**Deadline 4: Applicant's Response to Examining Authority's
Second Written Questions (ExQ2)**

**Wheelabrator Kemsley (K3 Generating Station) and Wheelabrator Kemsley North
(WKN) Waste to Energy facility Development Consent Order**

PINS Ref: EN010083

Document 12.2
May 2020 - Deadline 4

Graph 5.2.1: Maximum Predicted Process Contribution as Percentage of EAL vs Stack Height at Long-term IED Limits

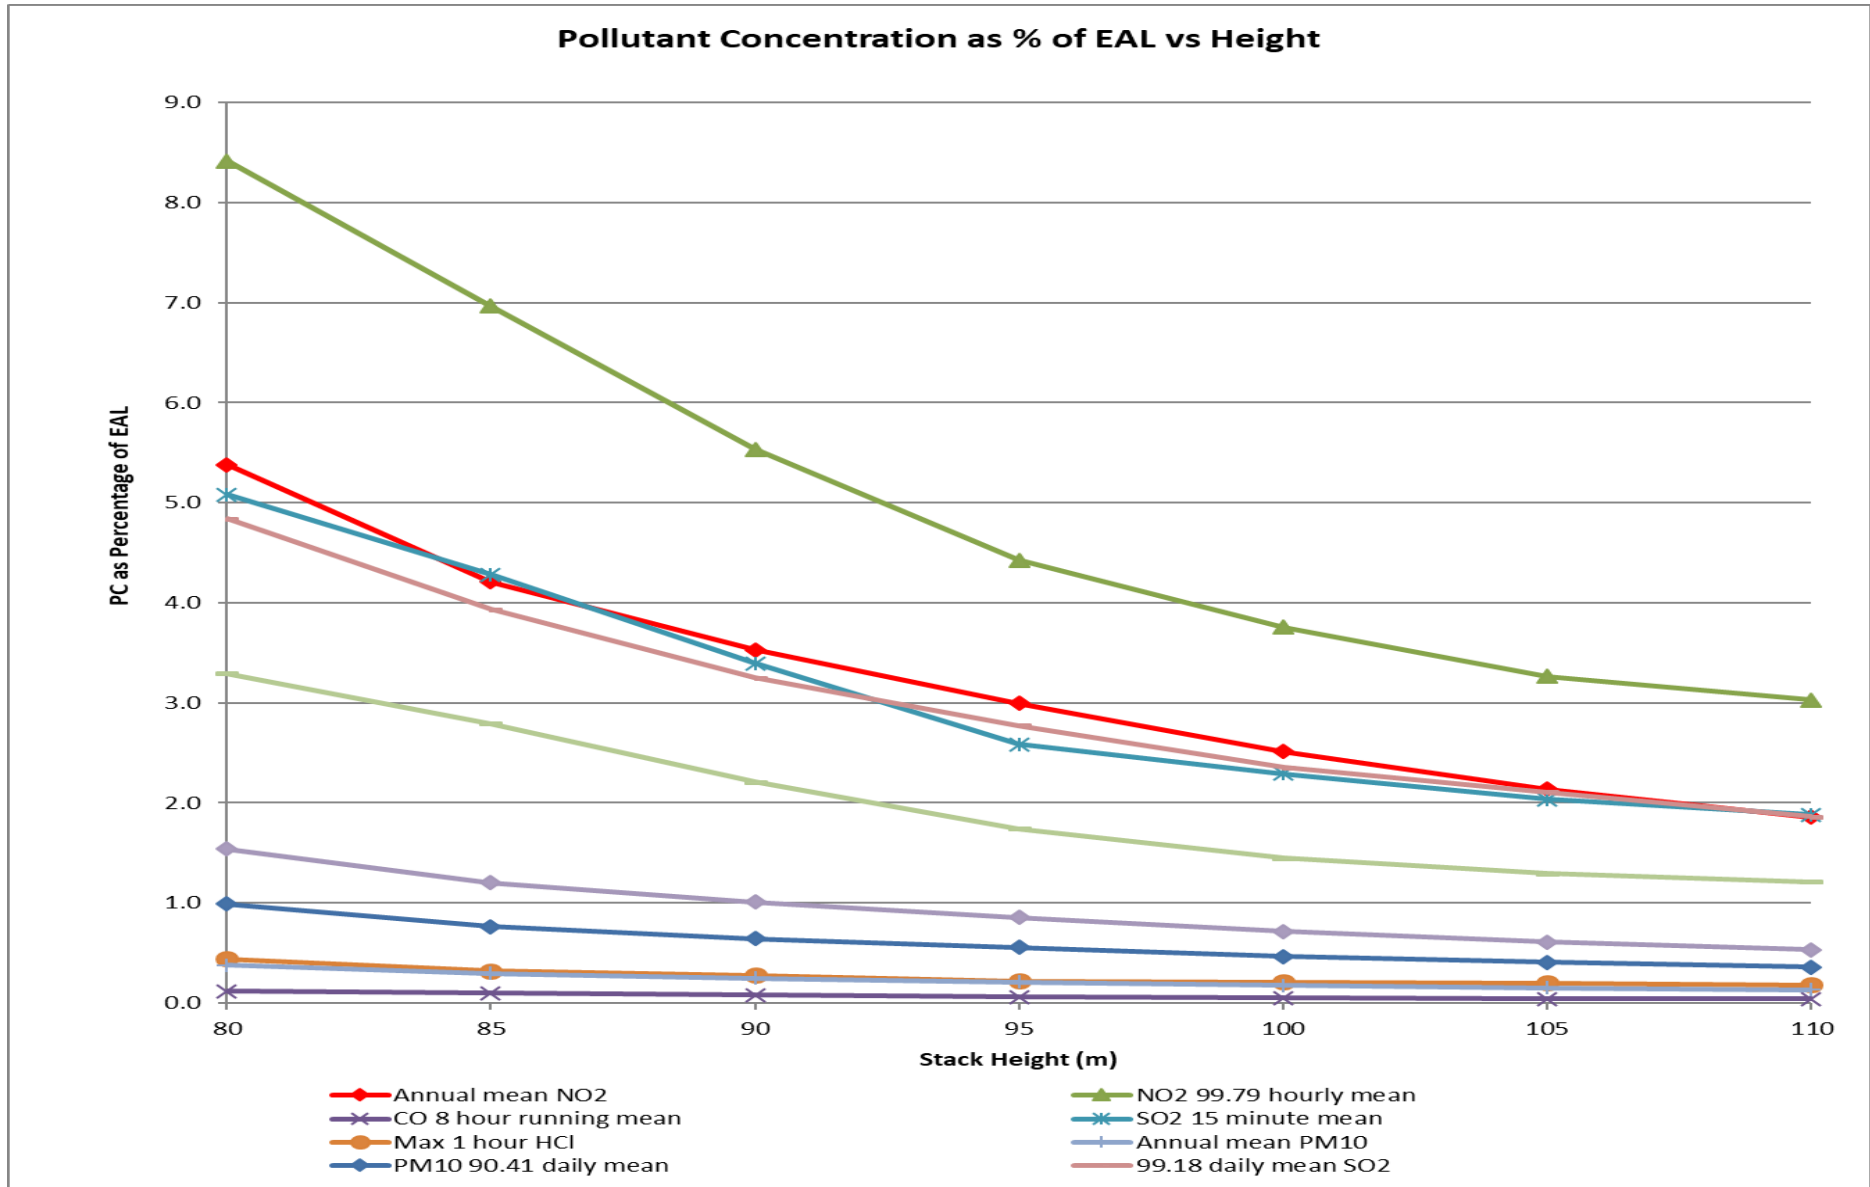
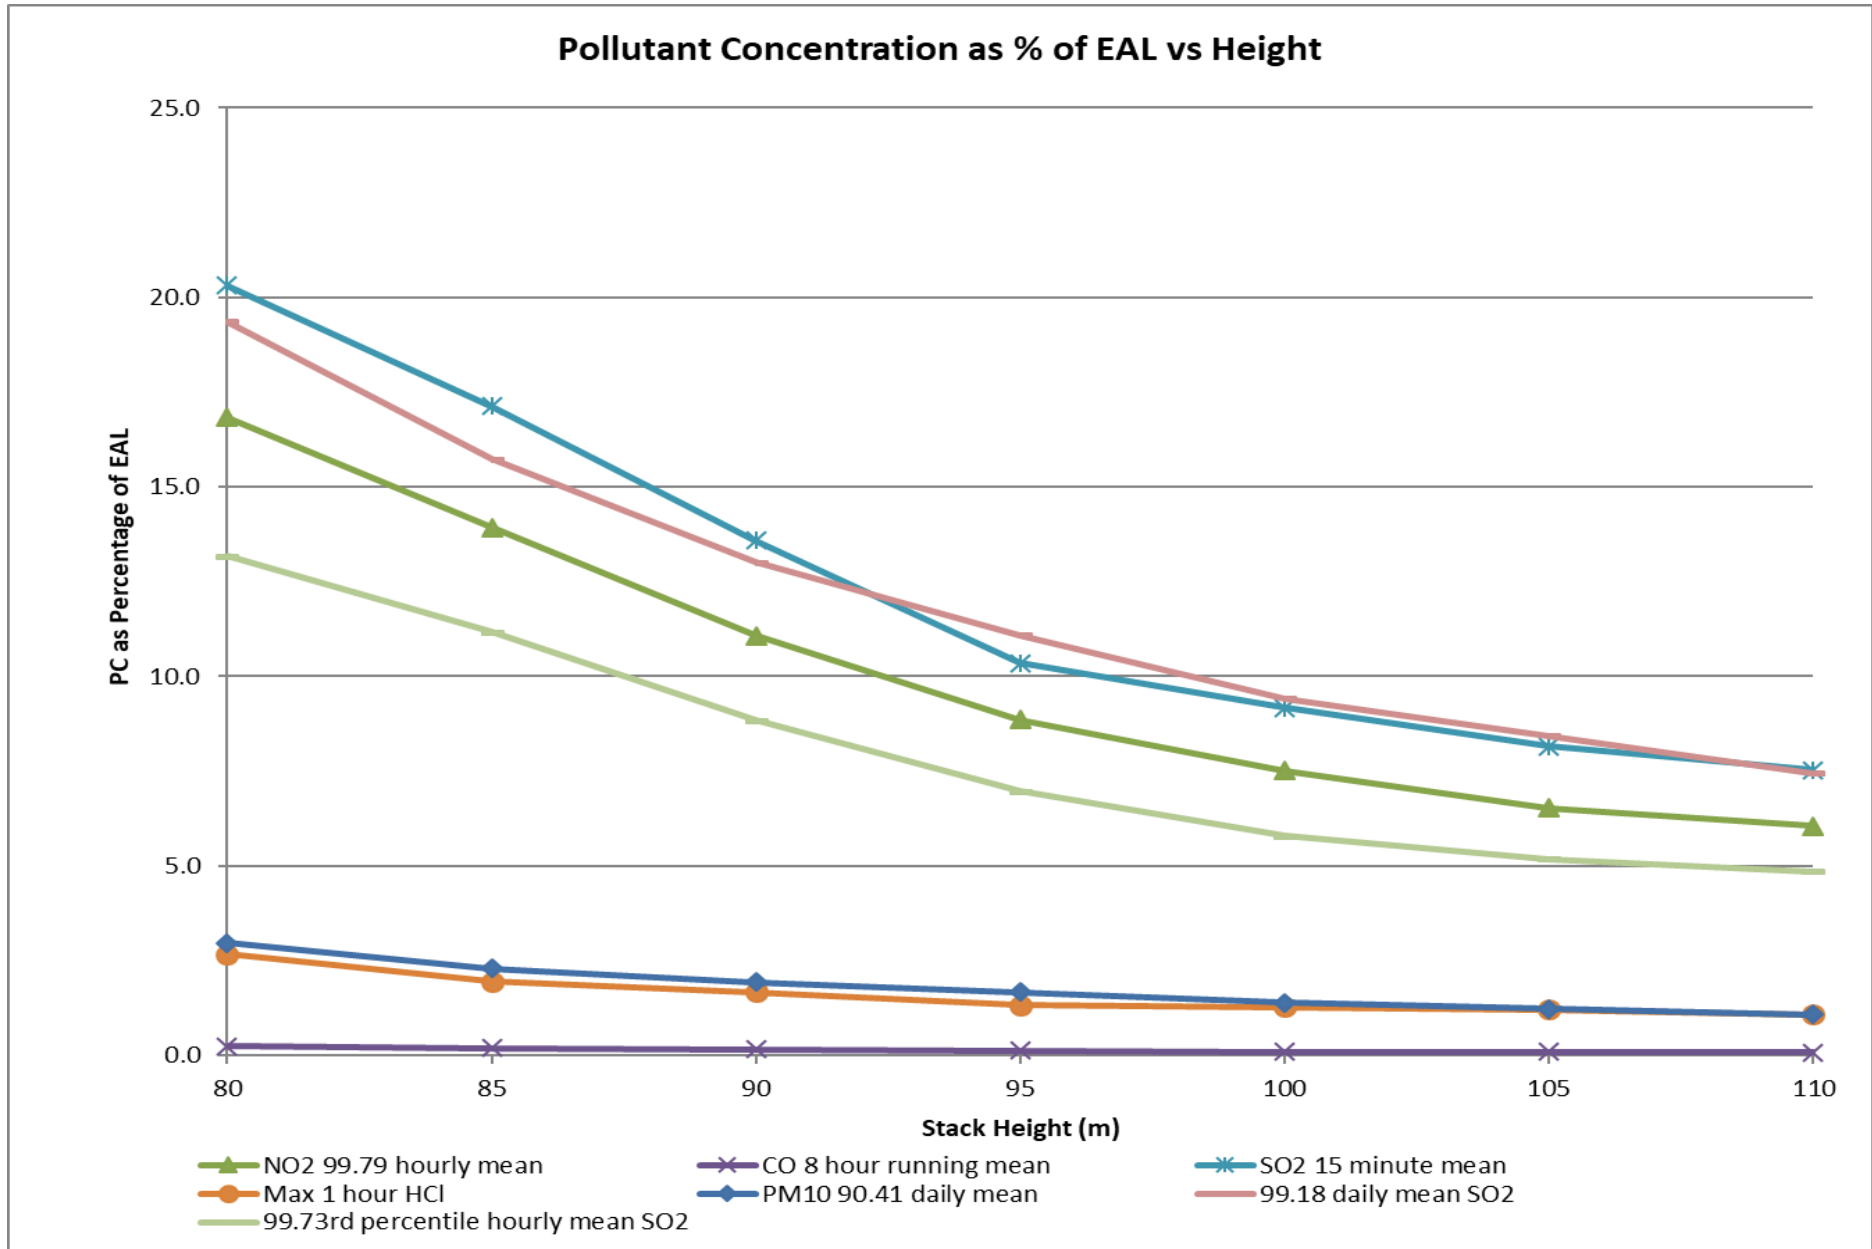
5.12 Q2.5.12 – Applicant - ES Appendix 5.2: Stack Height Determination for WKN is updated (no date in document) at D2 Submission [REP2-030, REP2-031]. It is stated that the stack height may be subject to change and may increase as the detailed design for the WKN Proposed Development continues to evolve. The stack height will be confirmed as part of the formal submission to PINS in spring 2020.

The original submitted Stack Height Determination [APP-026] stated that the stack height would be confirmed as part of the formal submission to PINS in spring 2019.

Please explain what submission or submissions have been made that confirms the stack height within the Proposed Development.

5.12.1 Table 1 of Requirement 14 of the draft DCO provides a minimum height parameter of 90m and a maximum height parameter of 99m for Work No 2 (f) Stack. The intention is to provide some design flexibility for the height of the stack but then to ensure clarity for the purposes of the EIA by defining a lower limit for air quality modelling and an upper limit for assessing landscape and visual impacts.

Drawing file: EN010083 / EN010083-000656-EN010083-K3-WKN-5-6-D2-WKN-Parameter-Plan-867-39 (1).pdf

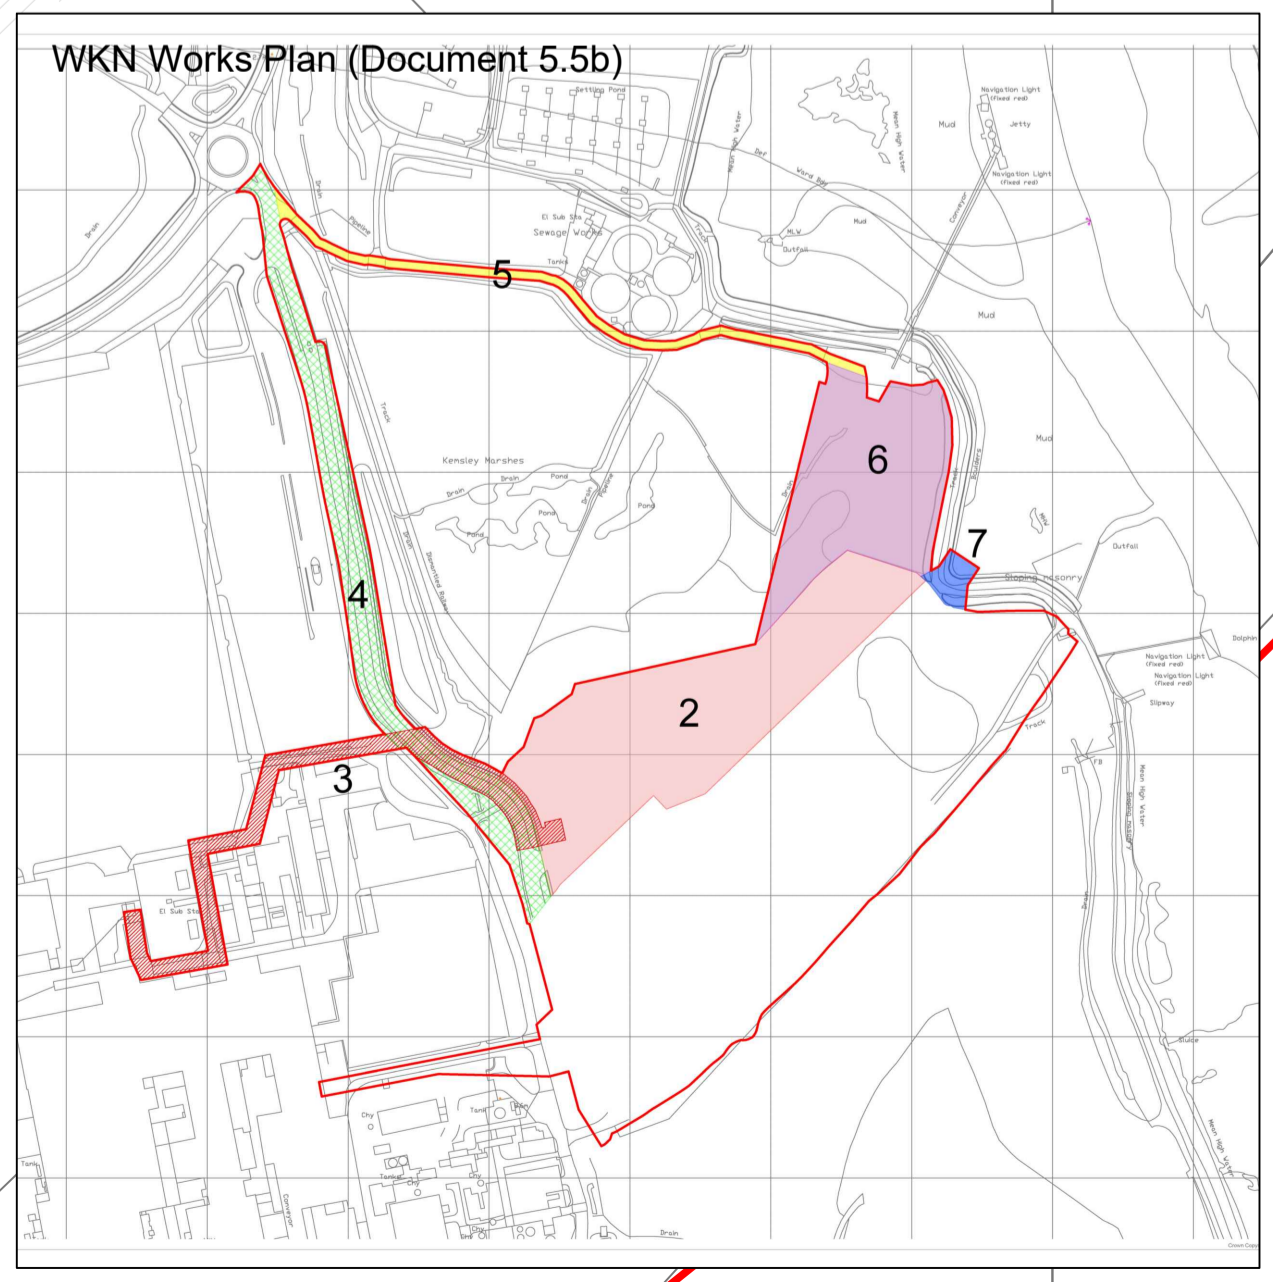
9.1 Q2.9.1 – Applicant - Regarding ExQ1.9.1 and the Applicant’s reply at [REP2-009] no detail of architectural treatments or surface finishes are included in the dDCO. The maximum design parameters for WKN have been modelled in the photomontages as simple grey forms.

Can the applicant explain how this fits with the good design principles set out in MHCLG’s National Design Guide (2019)?

9.1.1 The Applicant’s position is that the use of simple grey forms for the purposes of the Examination, when combined with Requirement 14 of the draft DCO which requires full details of siting, layout, scale and external appearance (including colours, materials and surface finishes) is both a necessary and appropriate approach to take in the context of this particular scheme.

9.1.2 The approach is necessary as no contractor has been appointed for the construction of the WKN facility. WTI’s experience of similar facilities ensures that they have the experience required to define a set of building parameters which reflects the required building dimensions for a facility of the scale required in order to allow for a robust assessment to be undertaken within the EIA.

9.1.3 The approach is appropriate in that Requirement 22 then provides the relevant planning authority with the opportunity to review the proposed design of the facility in full detail and will allow for an assessment of that design to be undertaken against the good design principles set out in MHCLG’s National Design Guide. Elements of the National Design Guide such as those sections addressing the Layout, Form and Scale of development are relevant to the current consideration of the grey forms used to indicate the parameters of the WKN facility and are assessed as such in respect of the Landscape and Visual Chapter of the Environmental Statement in particular. The approach taken by the WKN facility to addressing elements such as Appearance, Landscape, Materials and Detailing and other relevant Characteristics of good design set out within the National Design Guide would be considered as part of an assessment of the details submitted to address Requirement 14.

9.1.4 The position of the Applicant in respect of the WKN parameters proposed to be secured through the dDCO, in respect of the National Design Guide, is that they are appropriate in their scale and use to their context within an industrial area, adjacent to the existing K3 facility.
